DECISION DELEGATED TO HEAD OF PLANNING

Application No: H13-0962-25 **Applicant:** Mr A Hubbard

Proposal: Details of proposed means of foul and surface water disposal to separate systems, means of storage and disposal of refuse and recycling including management and maintenance, ecological biodiversity measures and water consumption (Conditions 5, 7, 9 & 10 of H13-0629-22)

Location: Adj. 2 Pipwell Gate Moulton Seas End Spalding

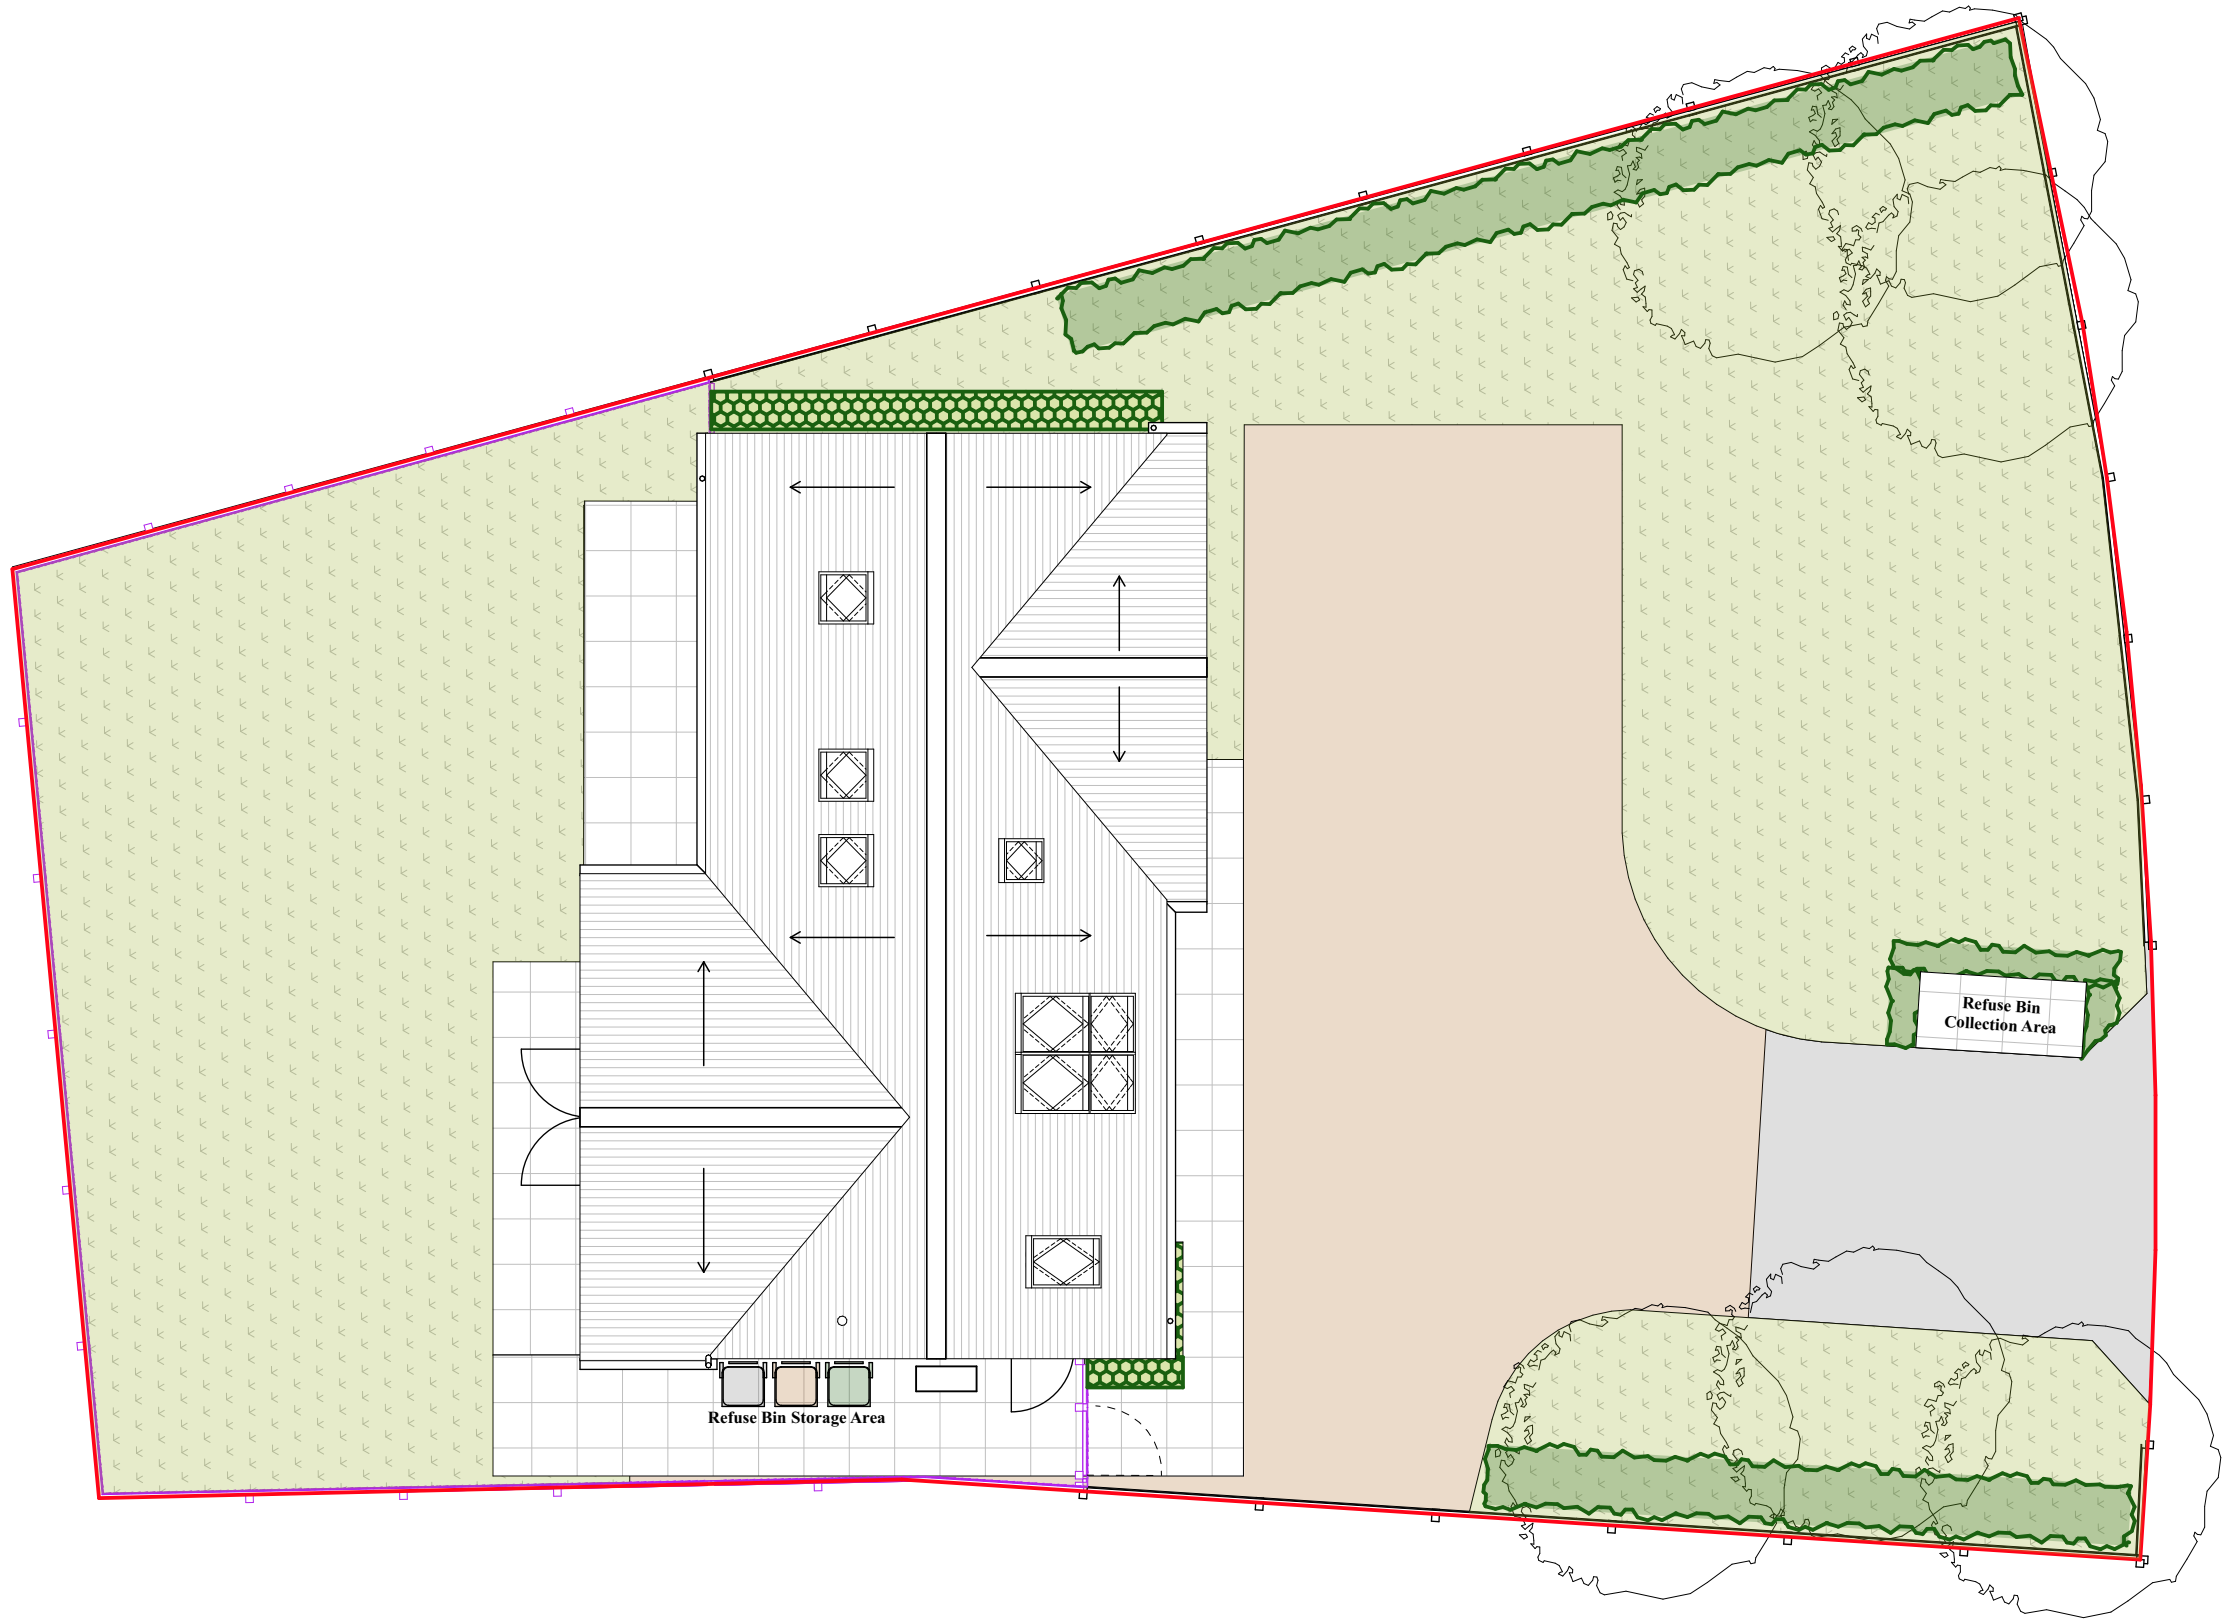
A small sealed area is proposed at the end of the drive, screened by low lying hedges. Given that this collection point would only serve a single dwelling, and would reasonably only be used during bin collection days, the proposal is considered to be acceptable and condition 7 can be discharged.

Planning Condition 9 - Ecological Plan

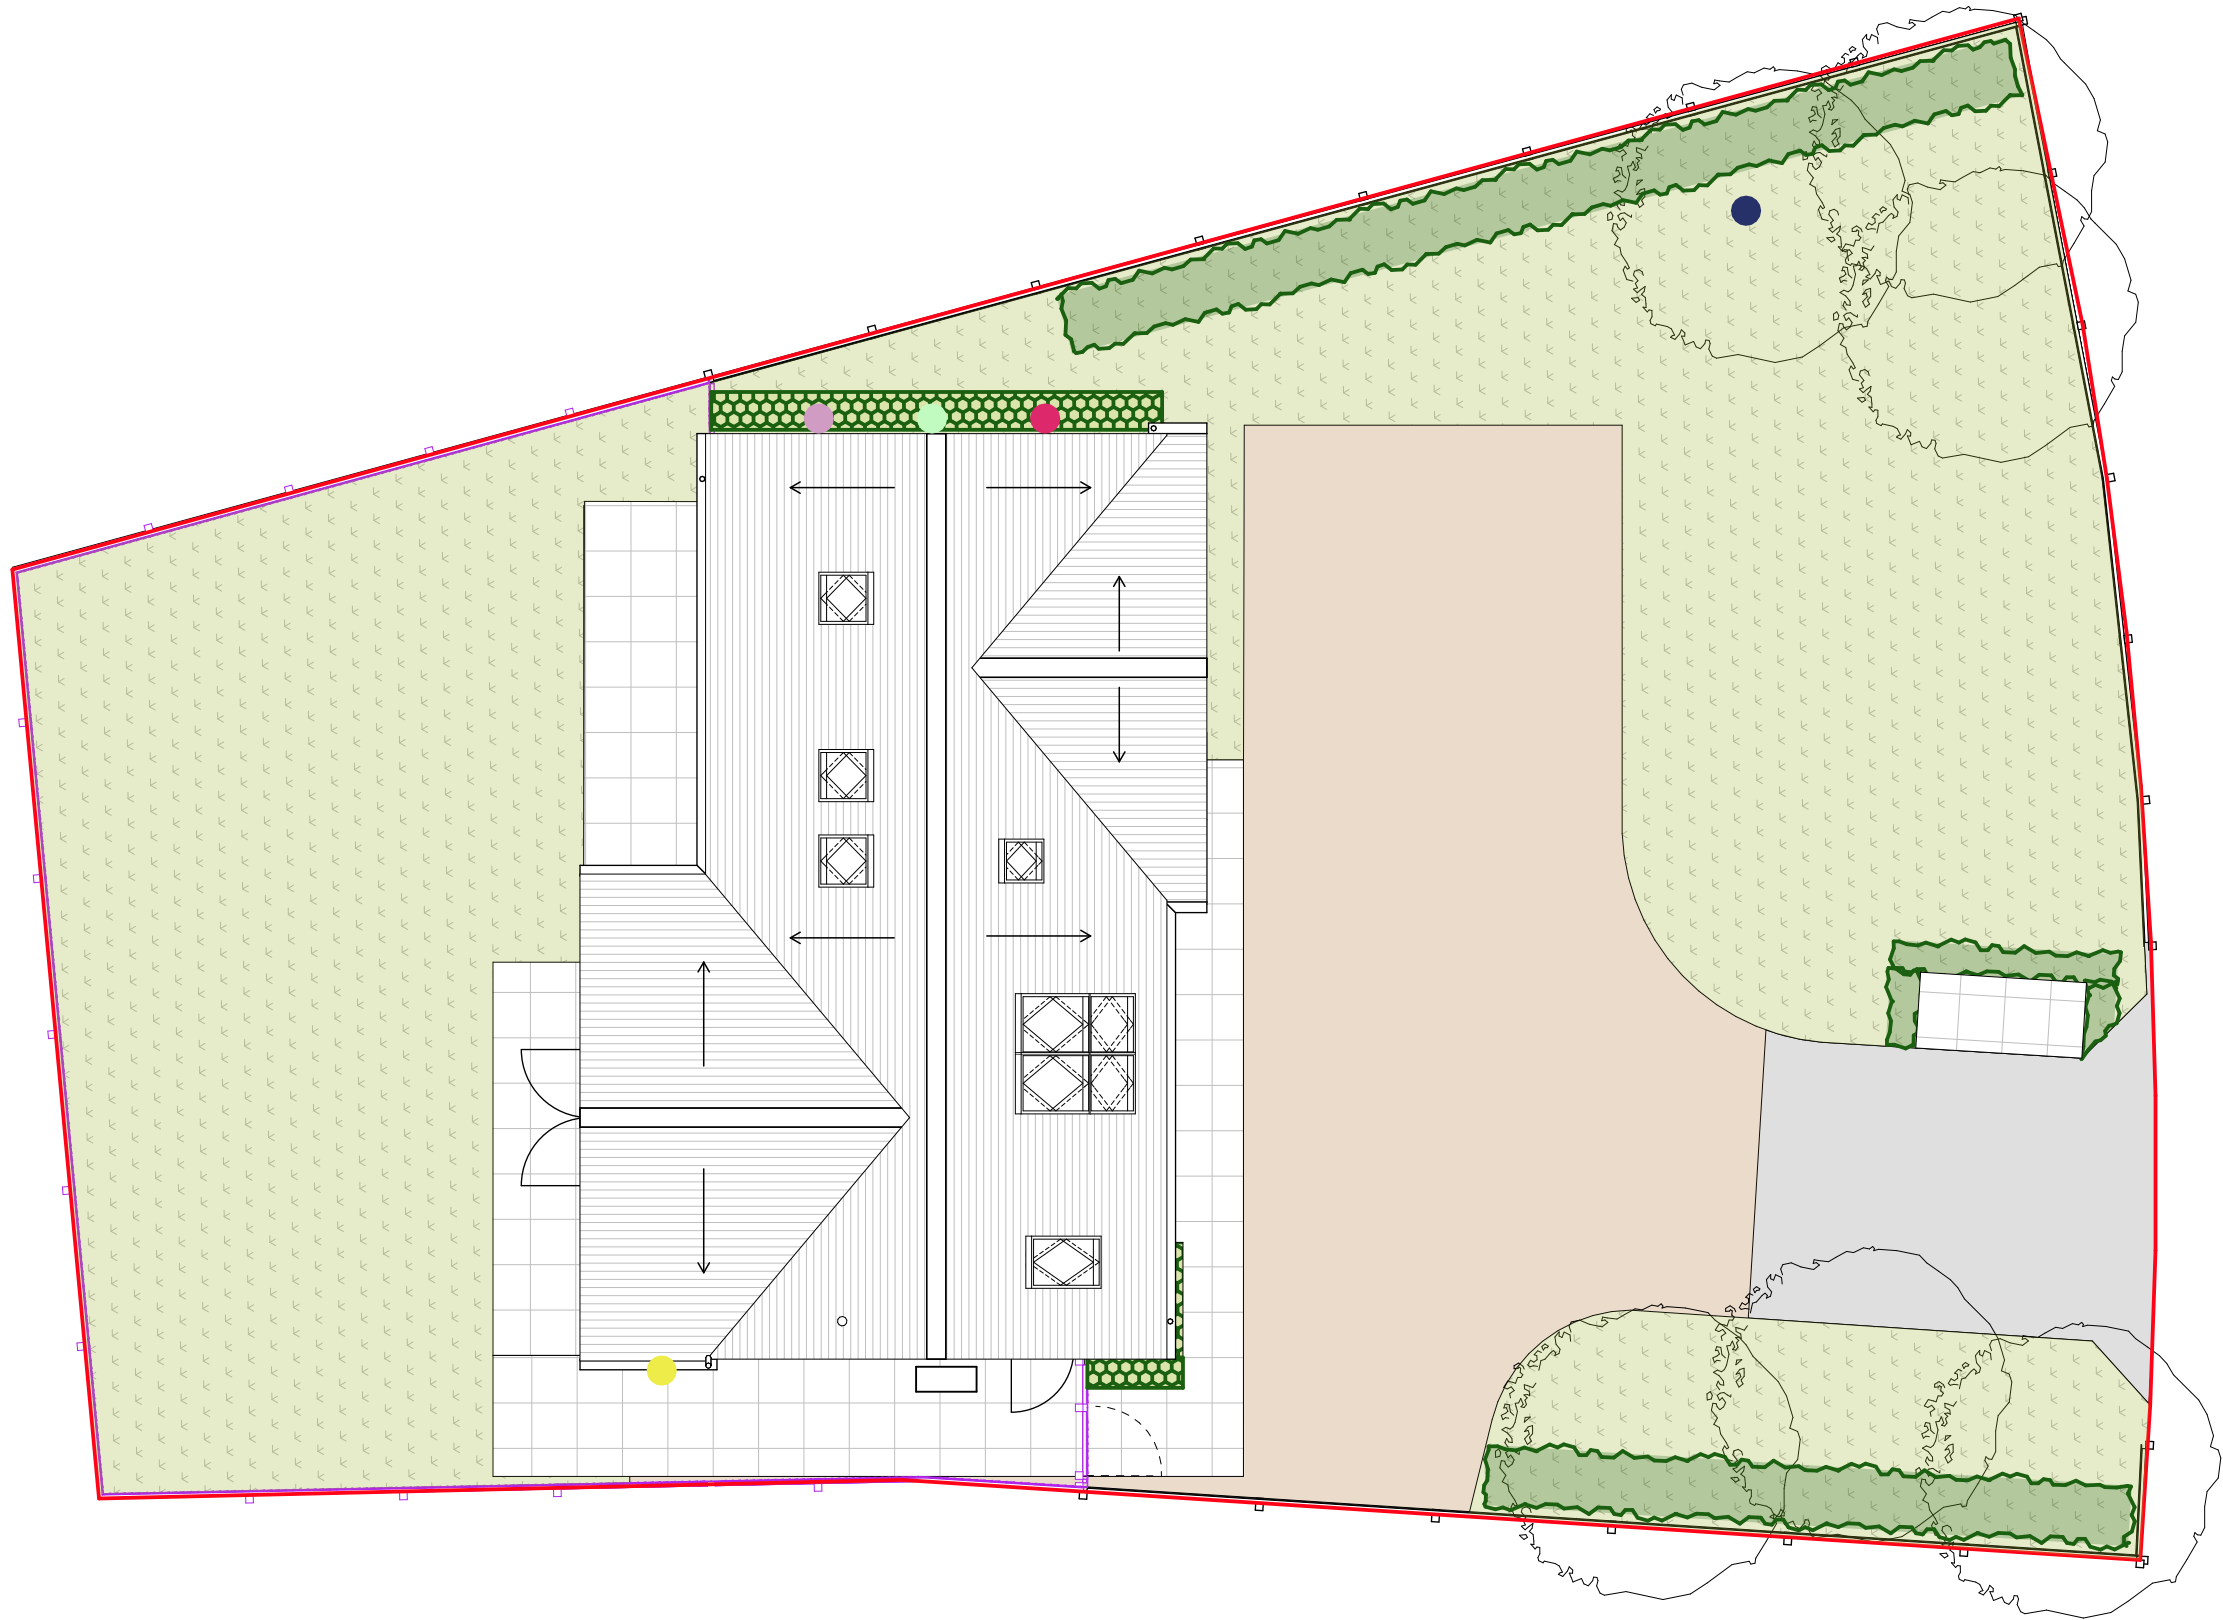
Proposed here is a scheme of planting, aligning with the details provided at Reserved Matters stage, which clearly show a net gain. In addition to this, the following is proposed:

- A bee brick on the east elevation
- A bird box on a north-western tree
- A sparrow box on the western elevation
- A swift box on the western elevation
- A bat box on the western elevation

The details provided are considered to be sufficient to display a net gain. As such, the proposal is considered acceptable and condition 9 can be discharged.

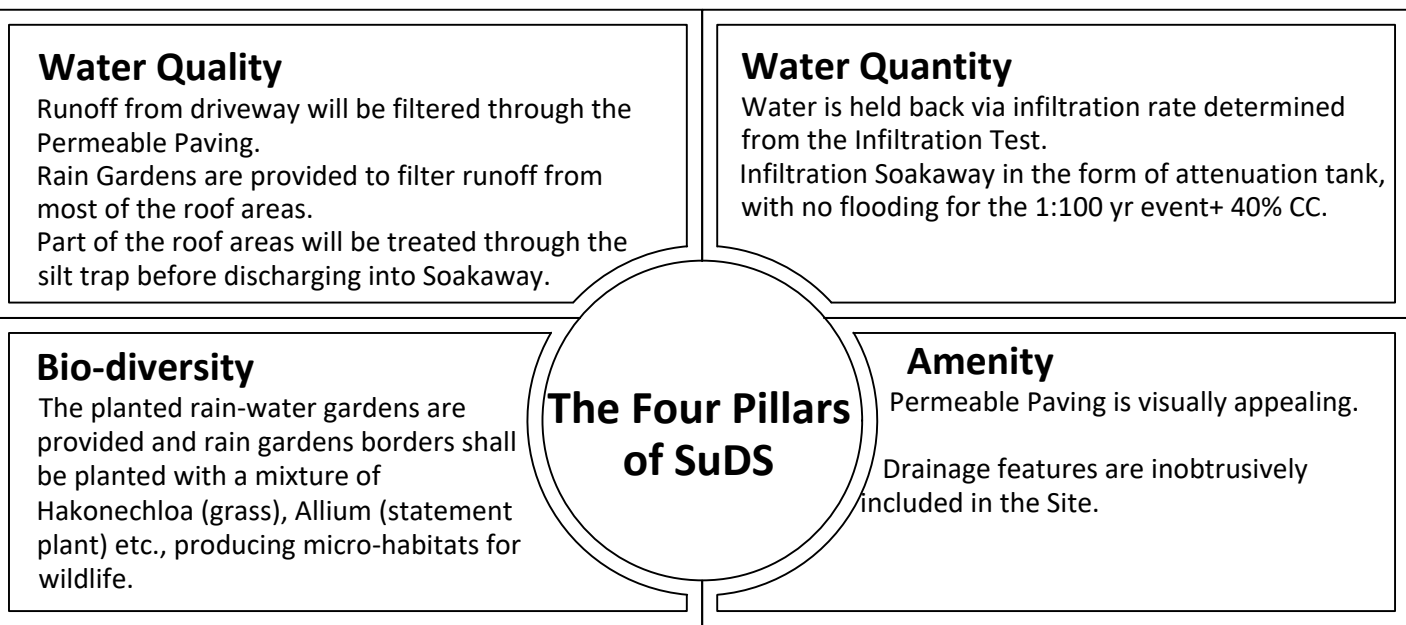
Foul water would flow into a cess pit below the driveway. Considering the scale of development and its semi-rural location, this is considered to be acceptable. The cess pit would be capable of dealing with the waste in a suitable manner.

Surface water will be disposed of via soakaways. Figures showing the viability of this method have been provided and, on this basis, the proposal appears to be agreeable.

The details provided are acceptable and condition 5 can be discharged.
